Laurie Leader - 131 Washington Avenue Plan Review Comments,

Please find my responses to your comments on drawings S-1 and S-2, regarding structural questions that you had.

Title:
**Main Block & Ell
 Foundation Plans
 and
 Sections**
 Sheet No: **S-1**

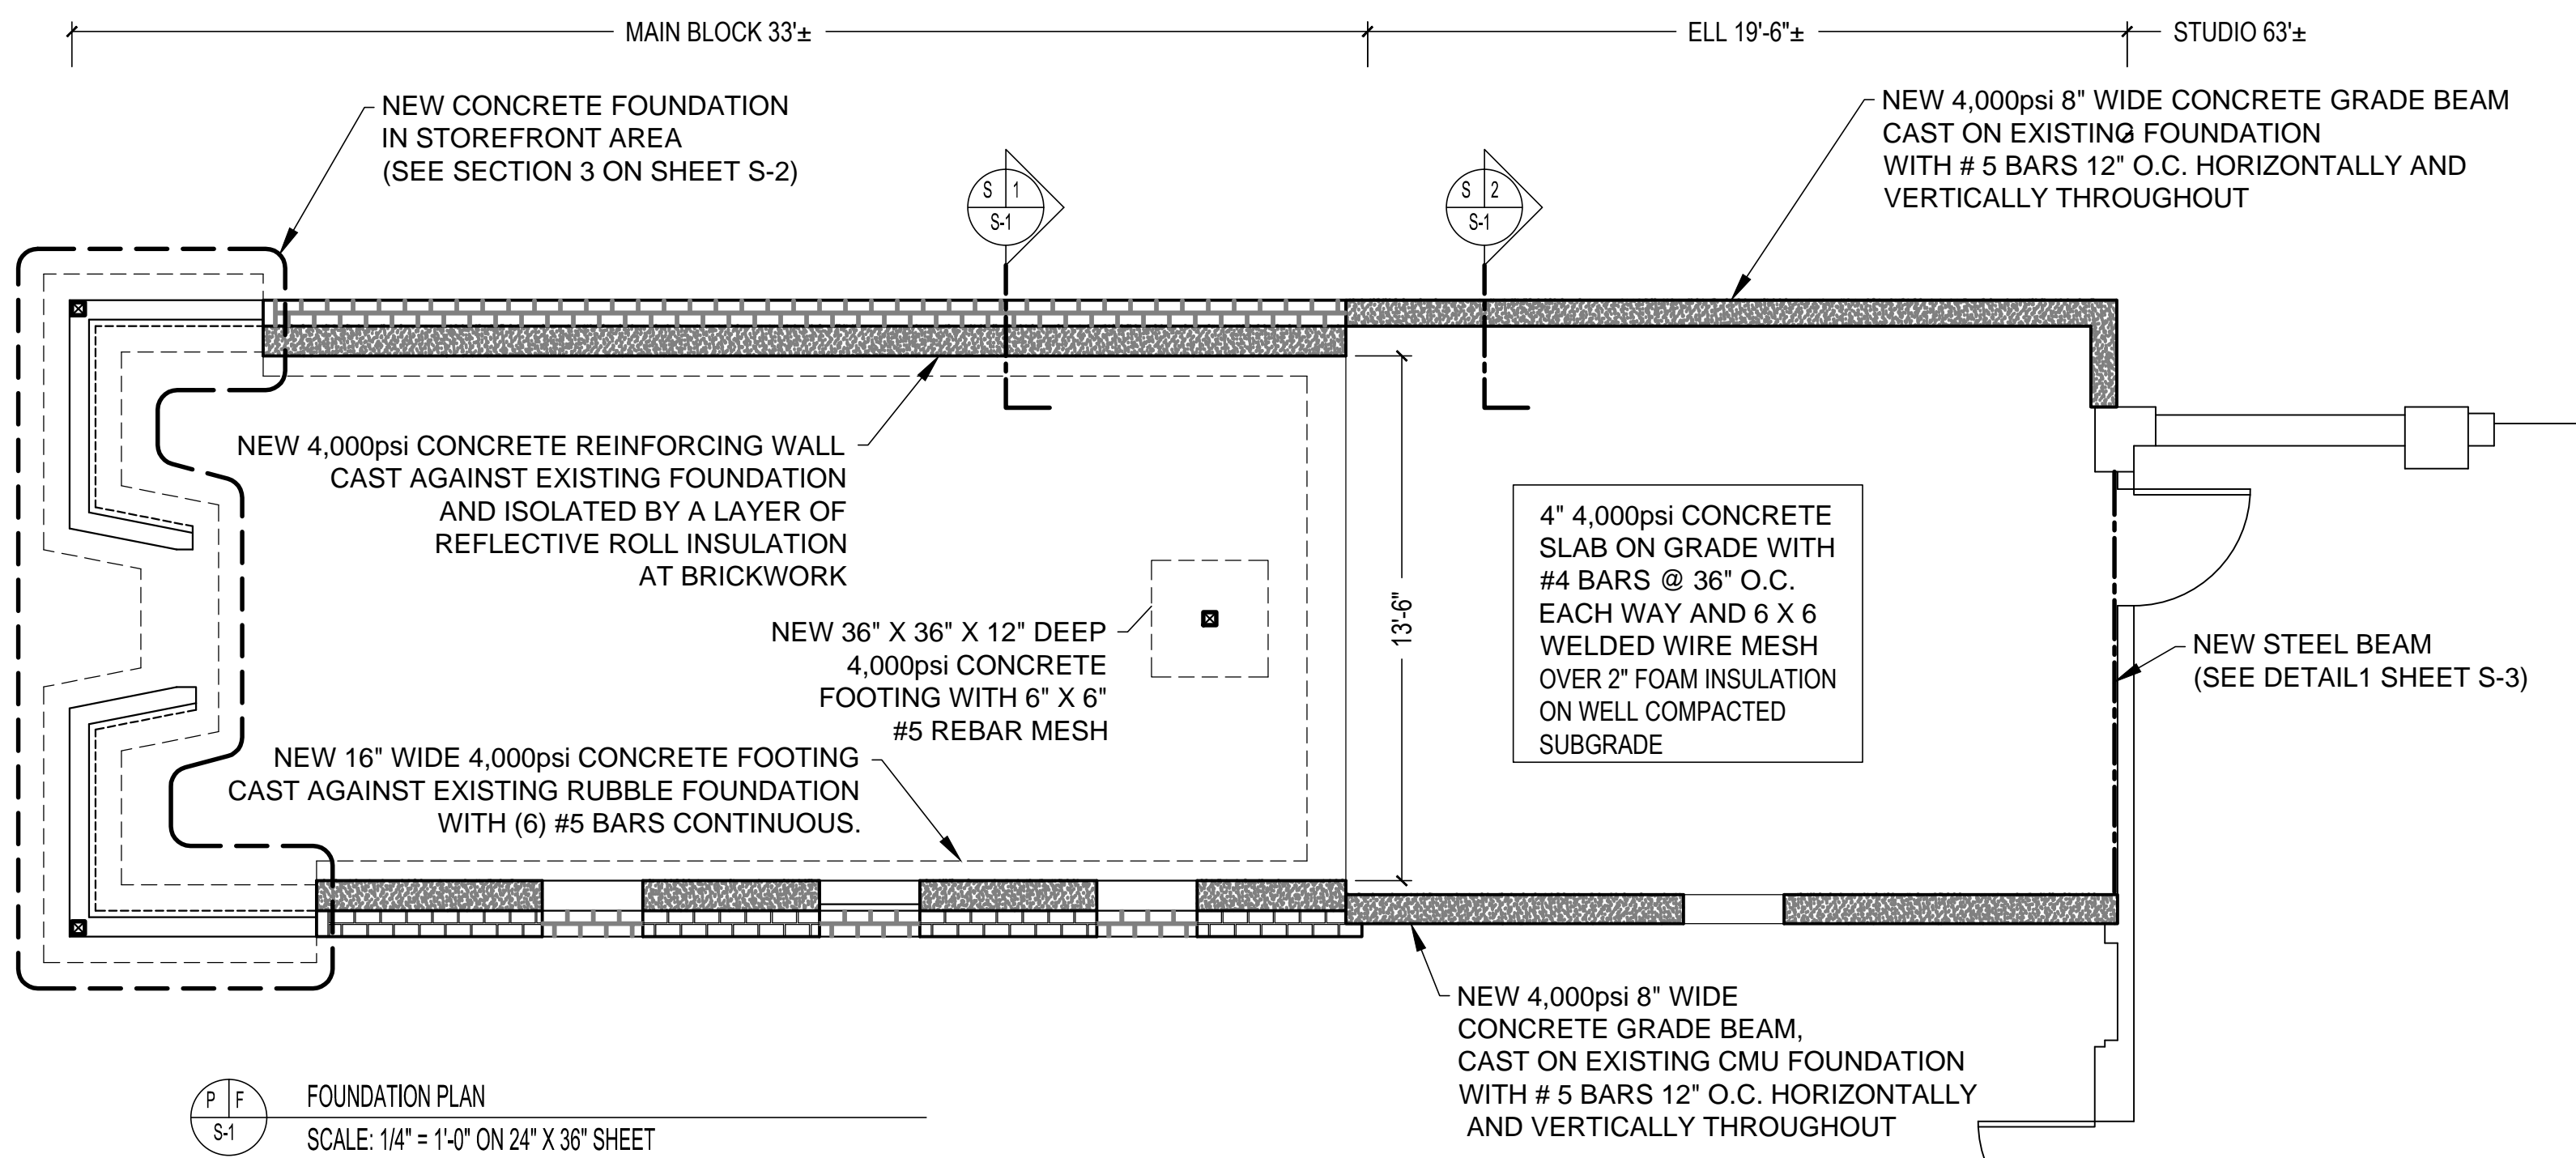
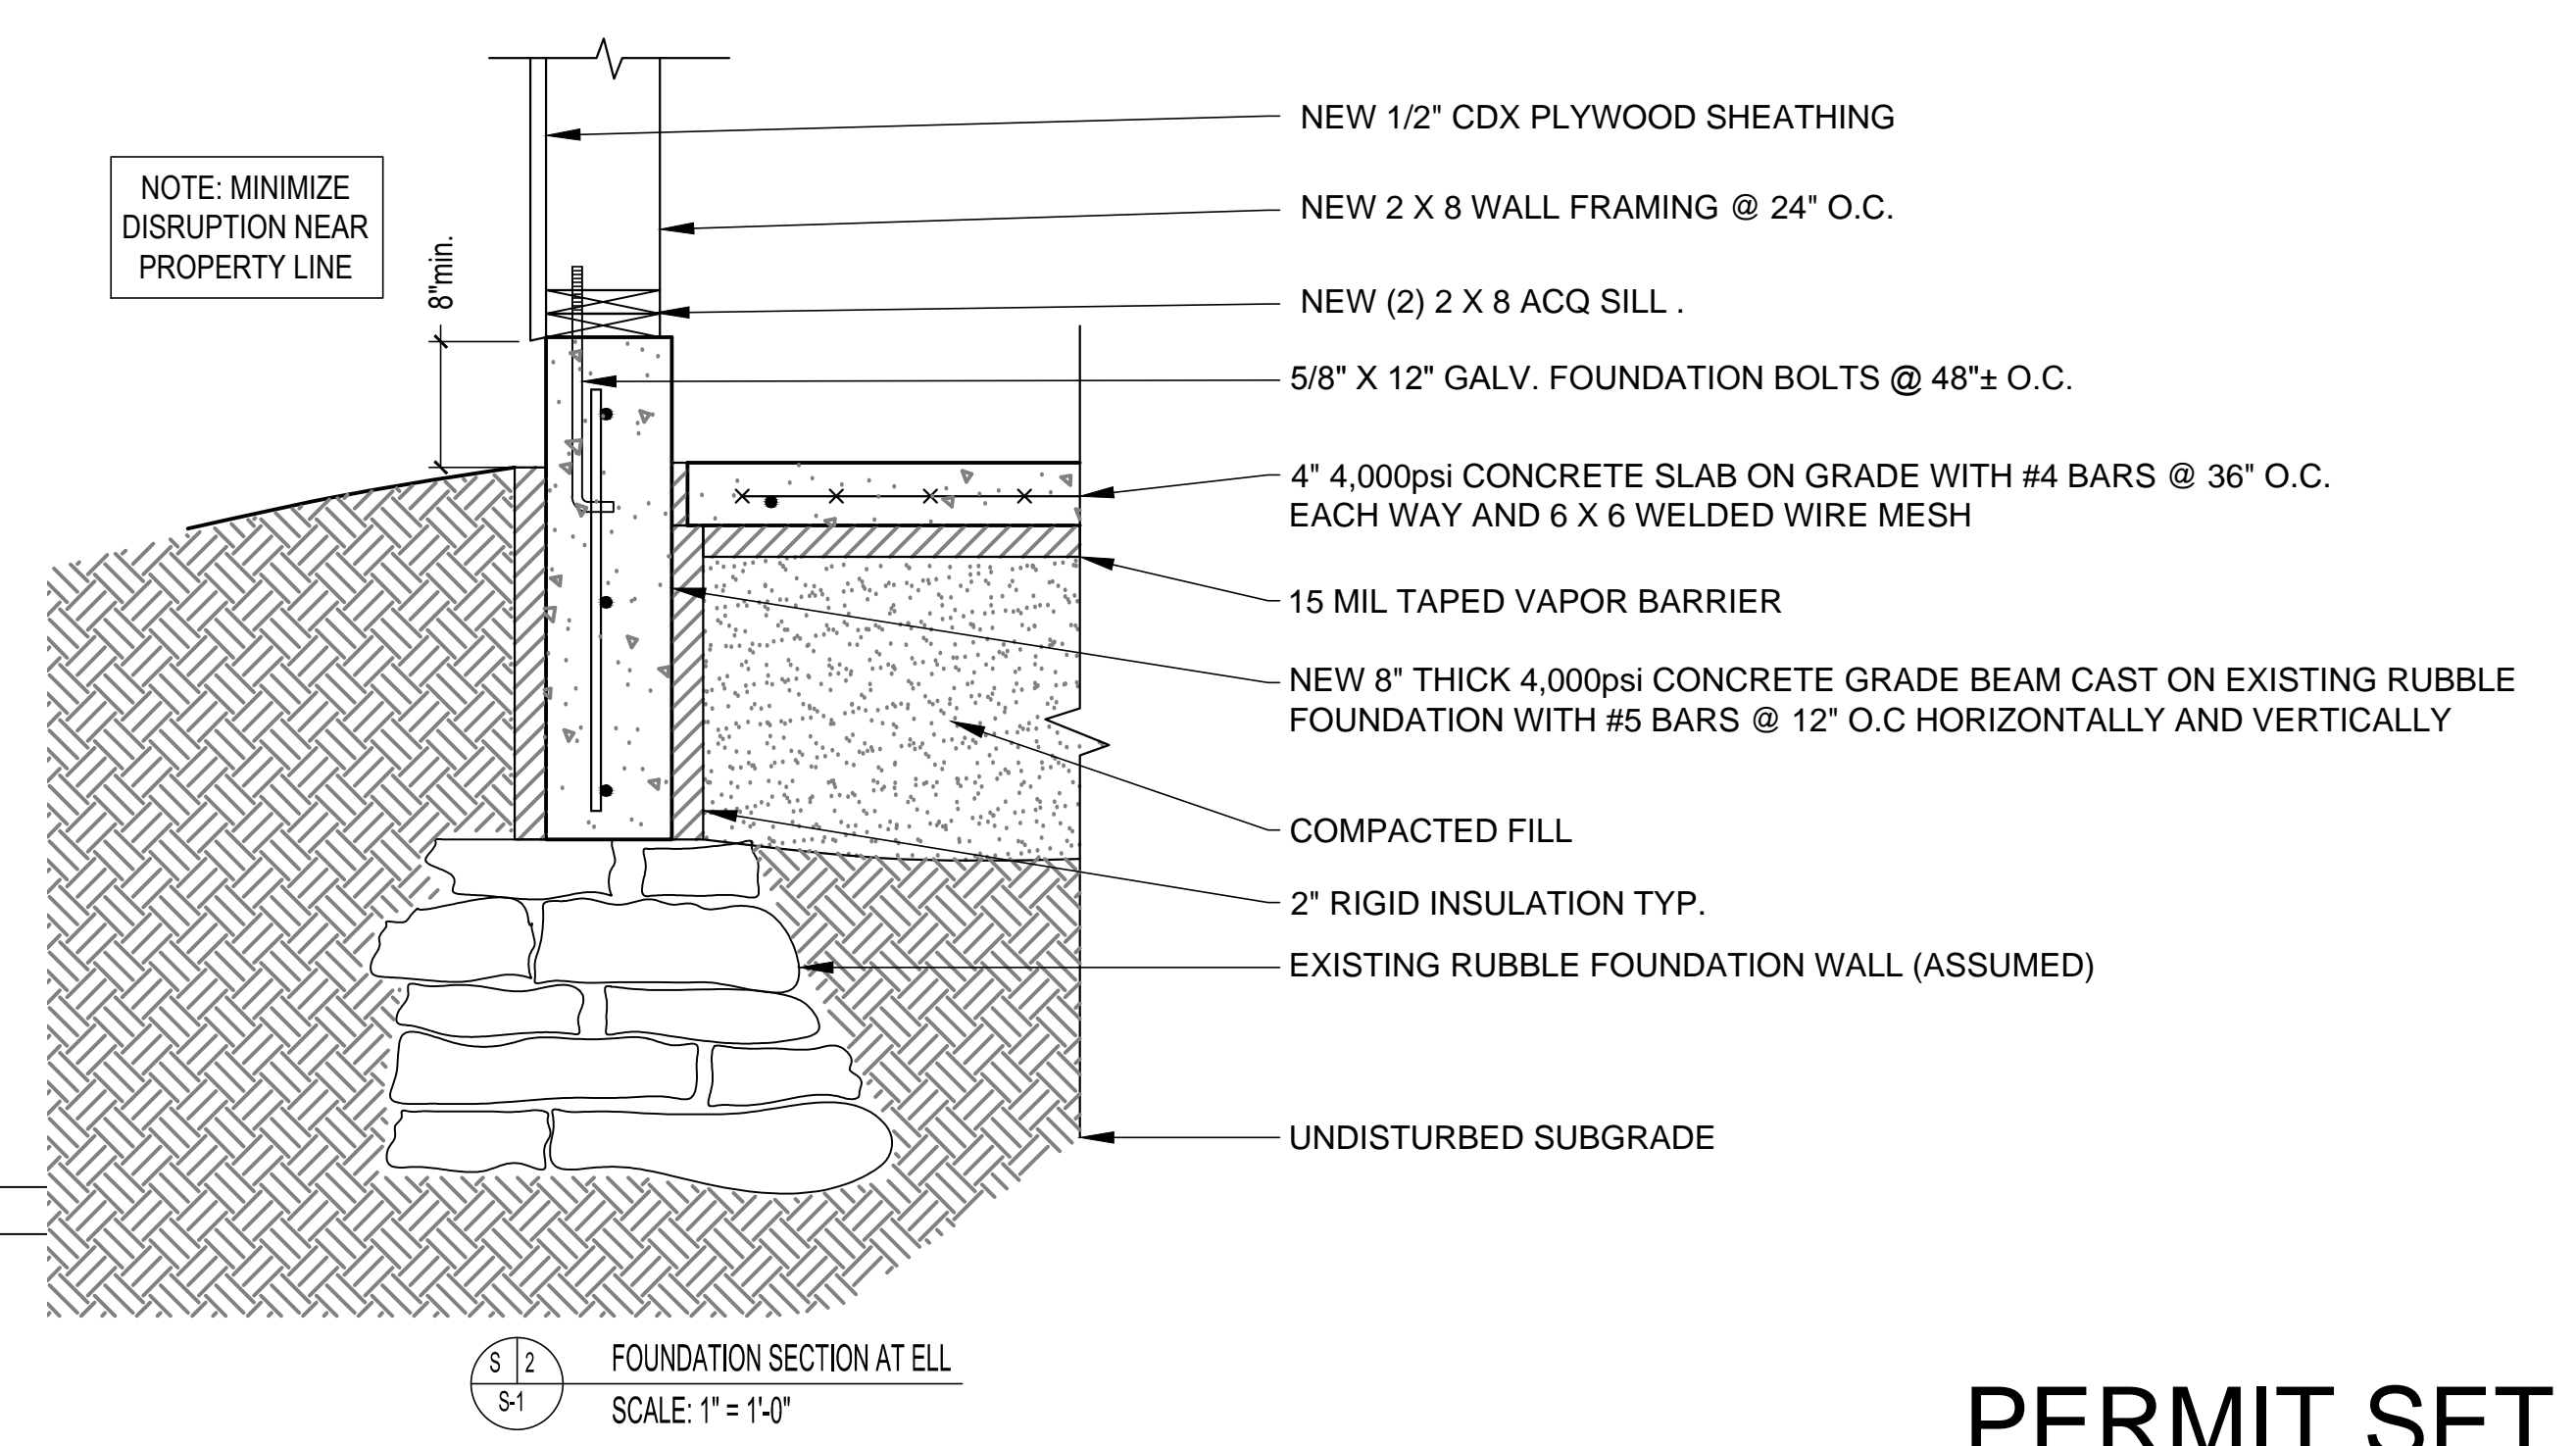
S-1 re: Foundation Work, I will confirm with building Owner Jon Edwards that I will perform appropriate construction observation to sign off on the structural sitework and structural building work as part of construction phase services.
